Site Plan Drawing_V2.pdf Markup Summary

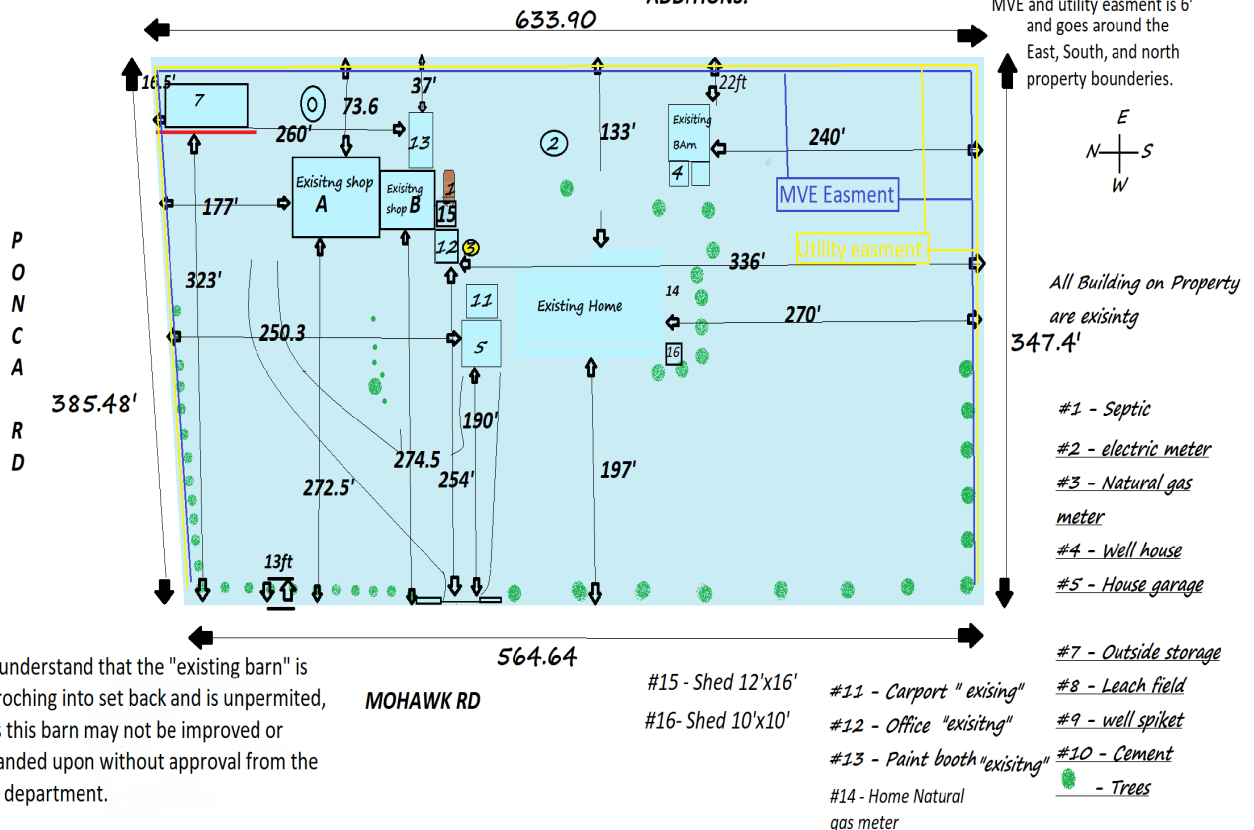
1. [Repeat Comment, comment unresolved]: Please add easements as noted on the title commitment and plat. (all side and rear lot lines have 6-foot utility easement per plat. There is also an MVEA easement shown on the previously approved site plan for AL137:

2. [Repeat Comment, comment unresolved]: Please add site data table. I see that you've included many items, but a few are missing. I need lot size, building coverage (how much SF of building as proportion of total lot size), and the breakdown of each building as part of that. Please refer to site plan example and include ALL property and building information shown on that plan, shown directly on the plan or on the data table, as appropriate per the examples. Access the site plan example via this link:

3. [Repeat Comment, comment unresolved] While the number of trees meets the minimum required for road frontage, but the depth of roadway landscaping does not meet the requirement for roadway landscape for nonresidential use separated by a residential zoning district by a road. The requirement is 15 feet depth (instead of 10') with 1 tree per 15 feet; or 64 trees along the road (1/3 of which have to be evergreens). If you will not meet this requirement, then you may request lesser roadway landscaping depth as part of an Alternative Landscaping Plan request. Please refer to the Roadway Landscaping and Alternative Landscaping Plan sections (sections 6.2.2(A) and (B)) provided via email to castrosbodyshop1@hotmail.com on 12/29. Please elaborate in letter of intent how your landscaping meets the intent of that code (screening, buffering, etc.)

PCD Note: outside storage (#7) is screened by opaque fence per Outside Storage requirements

PCD Note: existing barn encroaching into setback and is unpermitted. As such, please note that it cannot be improved or expanded upon without approval by the PCD Dept. Director to remedy the nonconformity.
